MARK UP OF OFFICERS REPORT
FROM PREVIOUS APPLICATION

APP. REF. NO: 74741/APP/2019/1194

Address 20 MILTON COURT ICKENHAM

Development: Single storey side/rear extension, first floor rear extension and extension to existing porch to front

STREET SCENE TO MILTON COURT – NO CHANGE

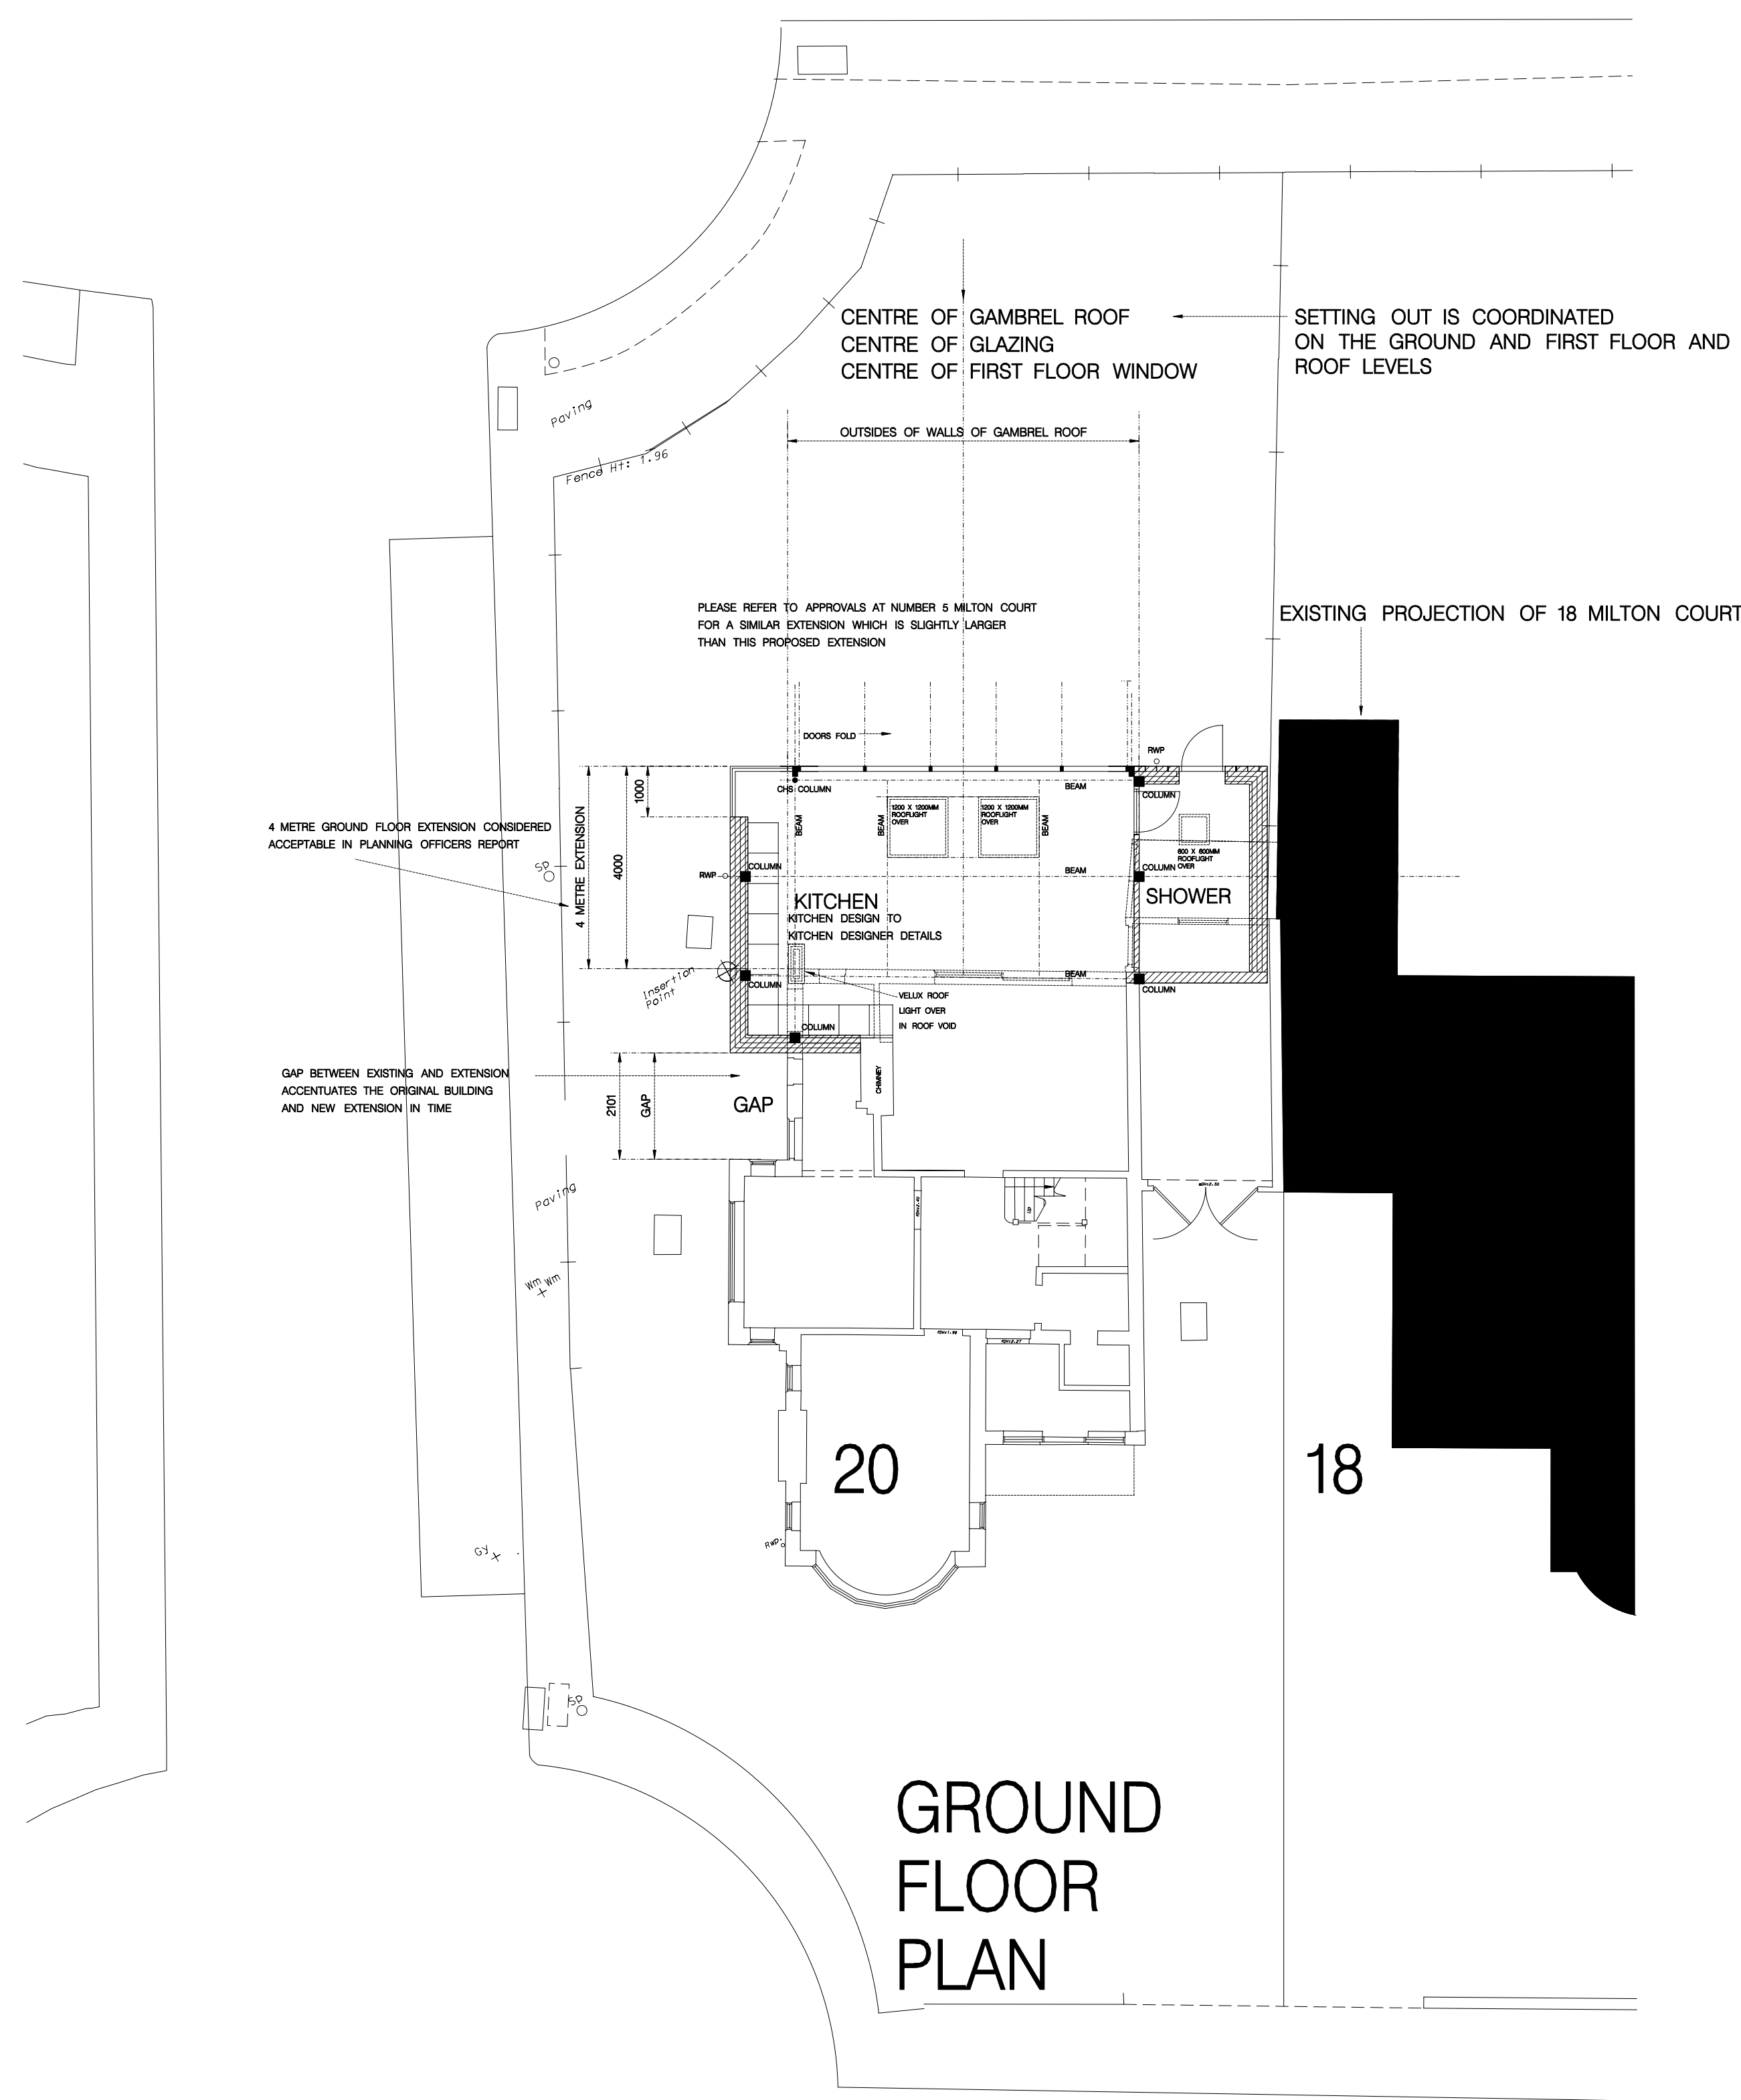
Proposed changes to the front elevation include the extension of the already filled in porch. These, originally open porches are a repeated architectural form within the close. It is felt that the proposed porch extension would hide the form of the original, which is still very much apparent in the structure, and that this would be a shame. No.18's extended porch appears to be a canopy only. However, if done well, the proposed porch extension could be acceptable. It might be better if the proportions of the house windows could be better represented in the design of the porch windows and door.

The proposed dummy pitched roof above the garage, while matching the height of the proposed porch roof and being designed to continue from the dummy roof of the rear extension, would spoil the continuity with the neighbour's garage roofline. With the loss of the dummy roof to the rear extension, it would seem there would be no need to change the roof of the garage. So on balance, it would seem better to maintain the neighbourly continuity, this will be easier to assess on any follow up drawings.

ARTS + CRAFTS DESIGN

AS
SEPARATE
APPLICATION

PROPOSED PLANS

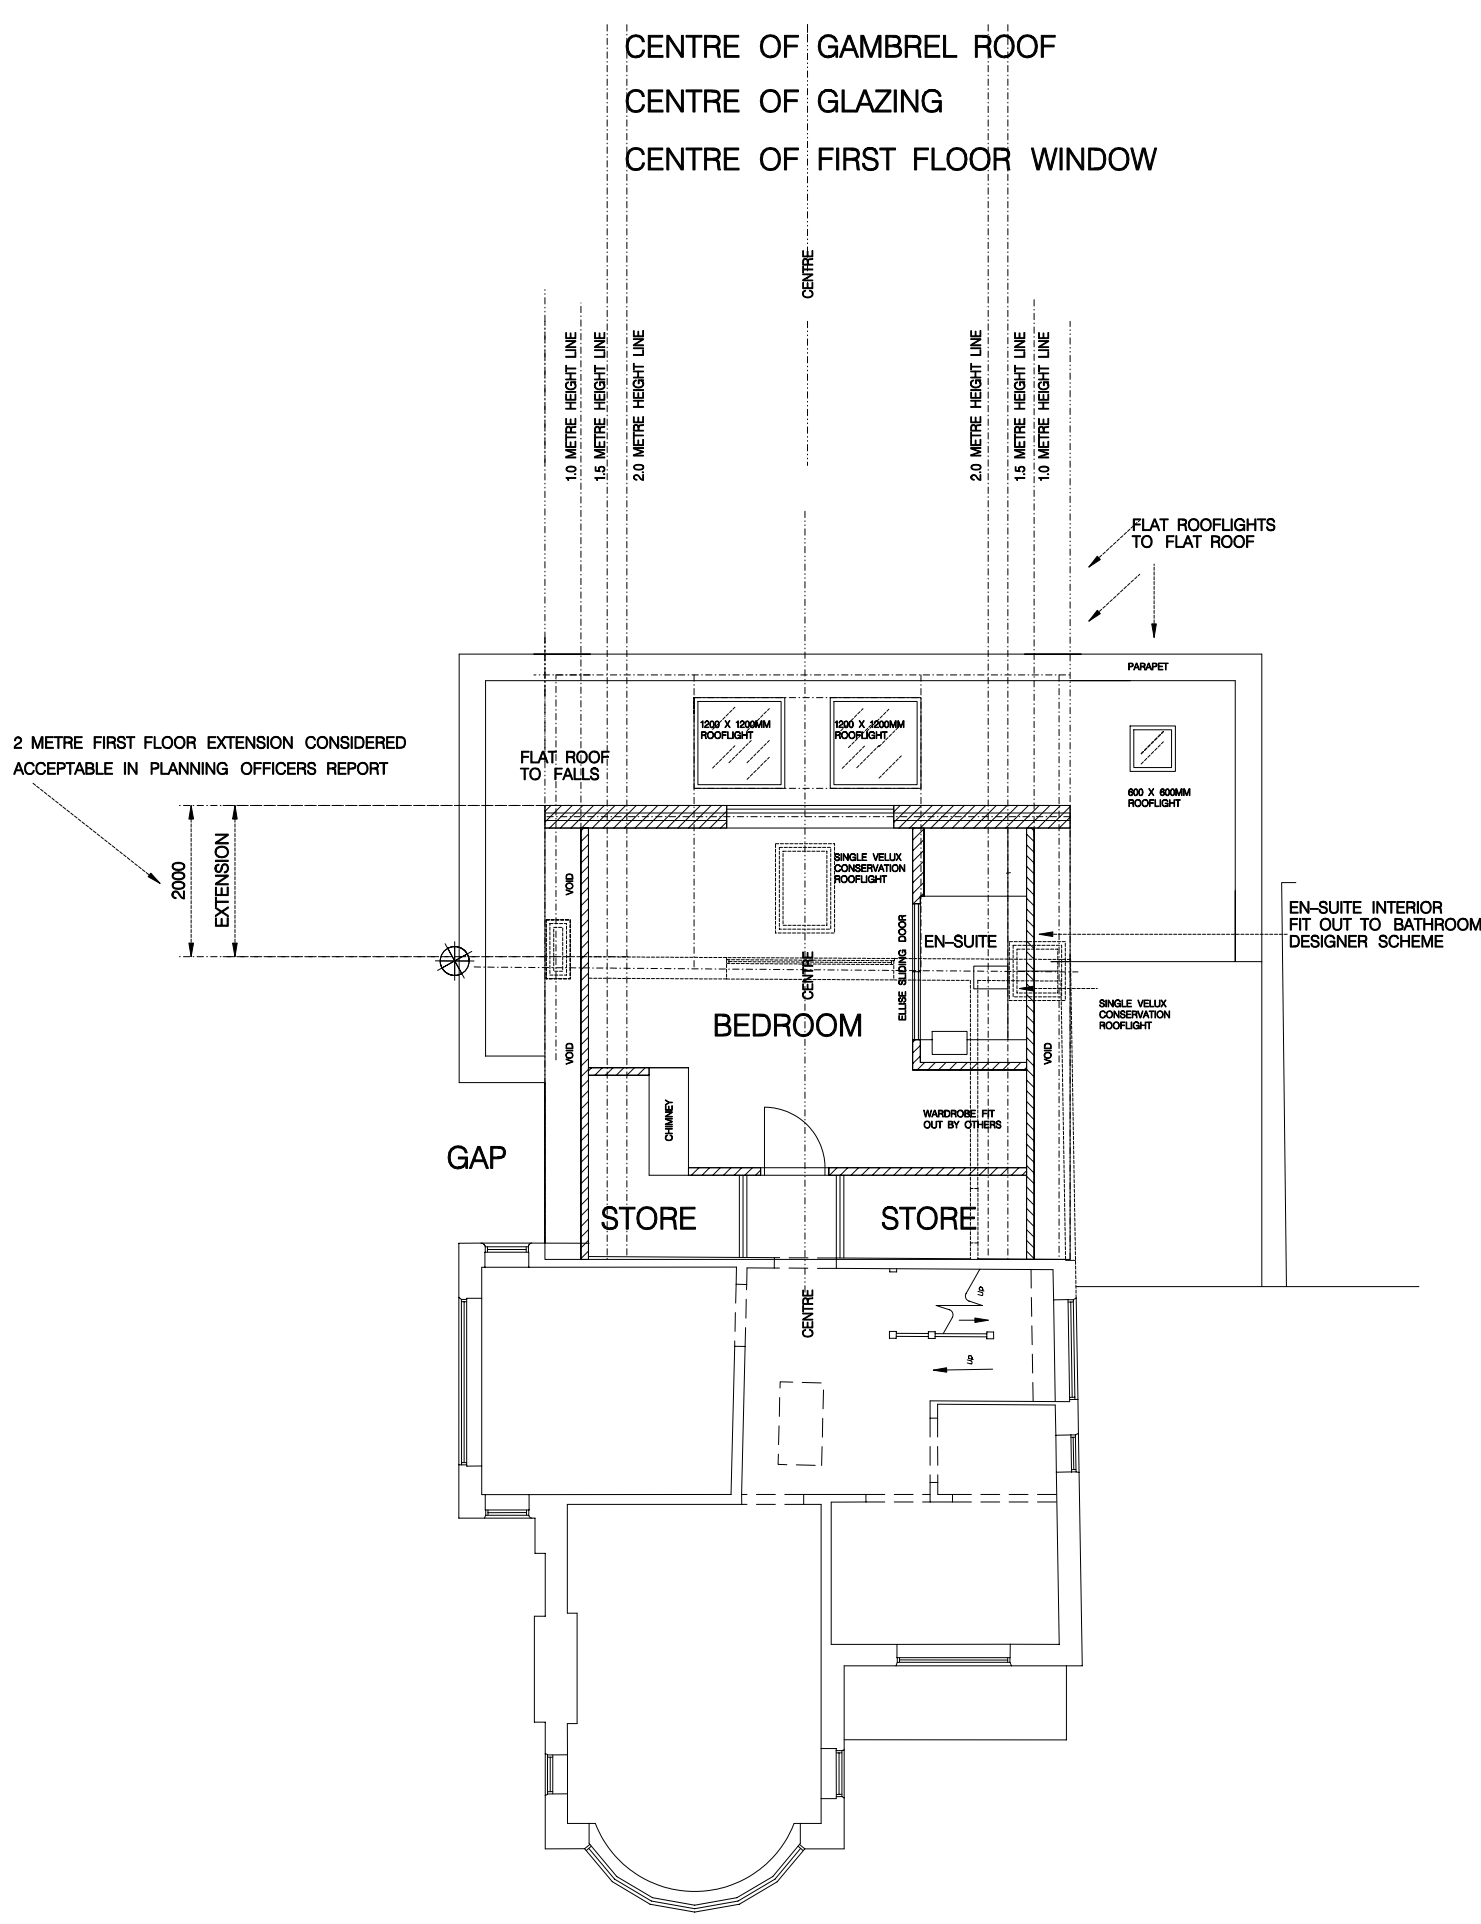
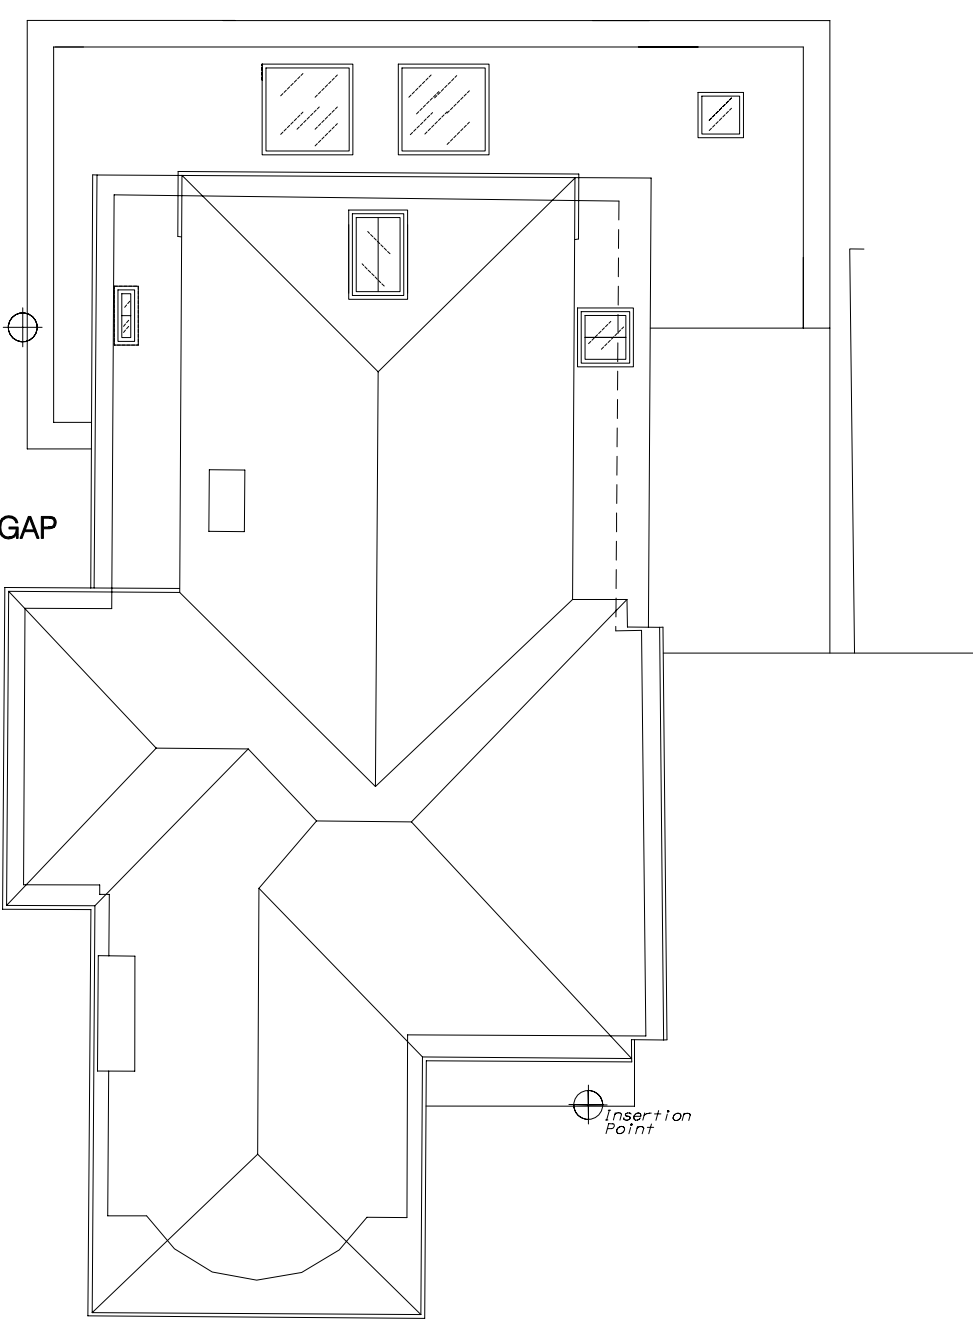
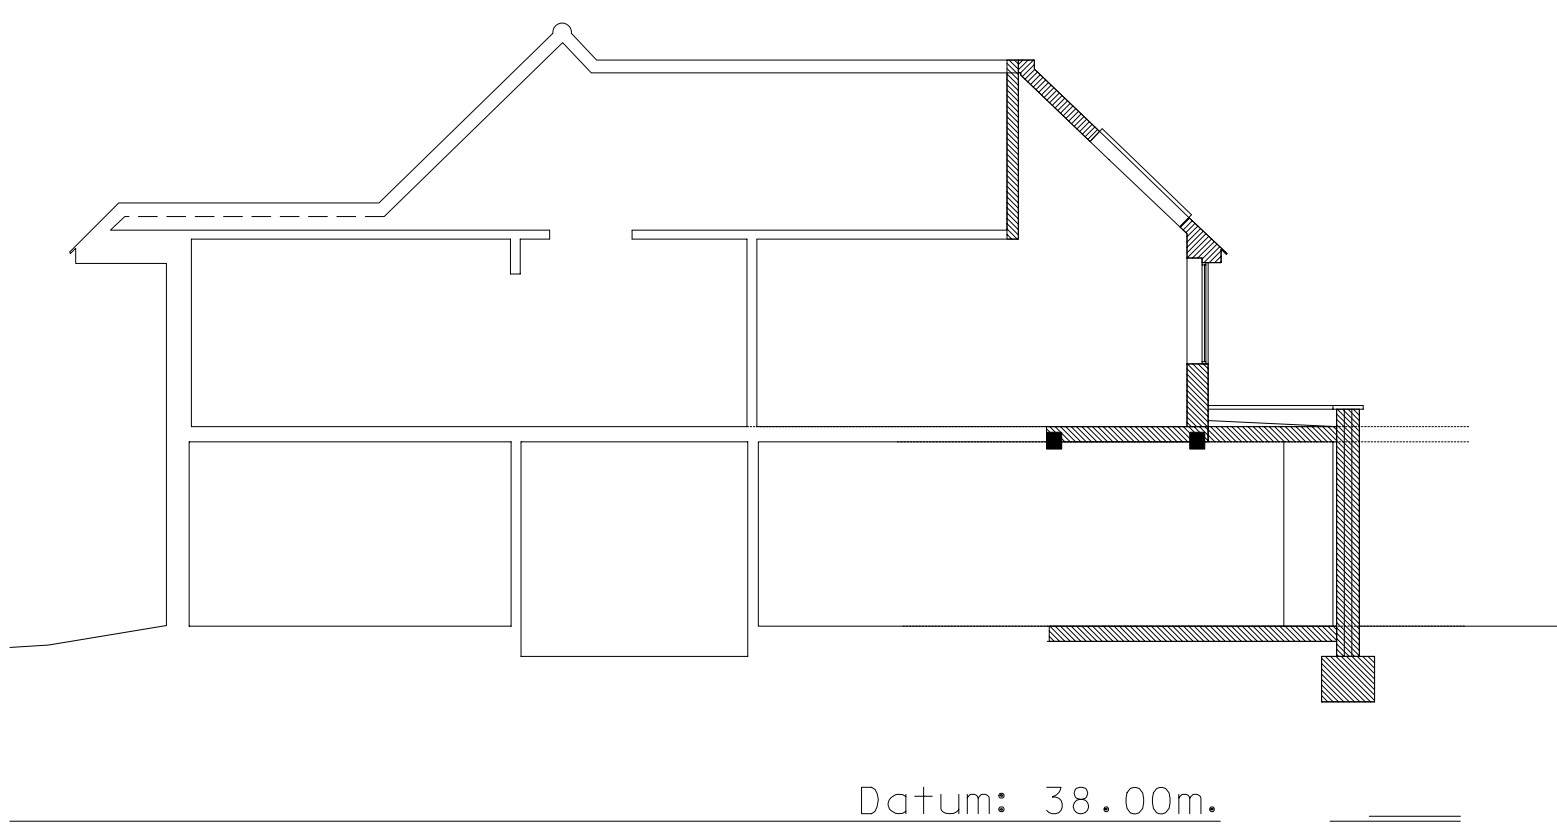
- It is considered out of scale with the plan form of the original building, the maximum depth to the rear of the property should be reduced to no more than 4m from the original building, in line with the HDAS guidance on extensions. It also eats into the garden, gardens being an important characteristic in the area. It should also not extend beyond the side elevations, especially not the west side, as this loses the form of the building.

- As can be seen in the drawings for the proposed scheme, the characterful rear elevation, framed so pleasingly by the half-hipped gambrel roof, is cut through by the proposed first storey extension and its mock pitched roof. This effectively deadens the pleasing vertical character of the original design form. The single storey element of the rear extension should be limited in width so that it is stepped in from the west side

The proposed use of a dummy pitched roof is inappropriate in this case as it clashes with the form of the gambrel roof. A low parapet may work better.

- The single storey extension to the west elevation, flattens out the step back to this side and disrupts the line of the gambrel roof, visually cutting it off where it is meant to sit over a vertical wall. The resultant proposed form is incongruous and hides the original form. The proposed high level windows are not in keeping with the existing windows and the eaves would extend forward of the bay to this side which is not desirable. As this elevation also contributes significantly to the interest of the street scene it fronts, the proposed side extension to the west is considered unacceptable.

✓ COMPRIES

- GAP PROVIDED - ALSO SAME WIDTH / LESS THAN S MILTON COURT.

SEE SYMMETRICAL
SET OUT ON CENTRE OF GAMBREL
ROOF
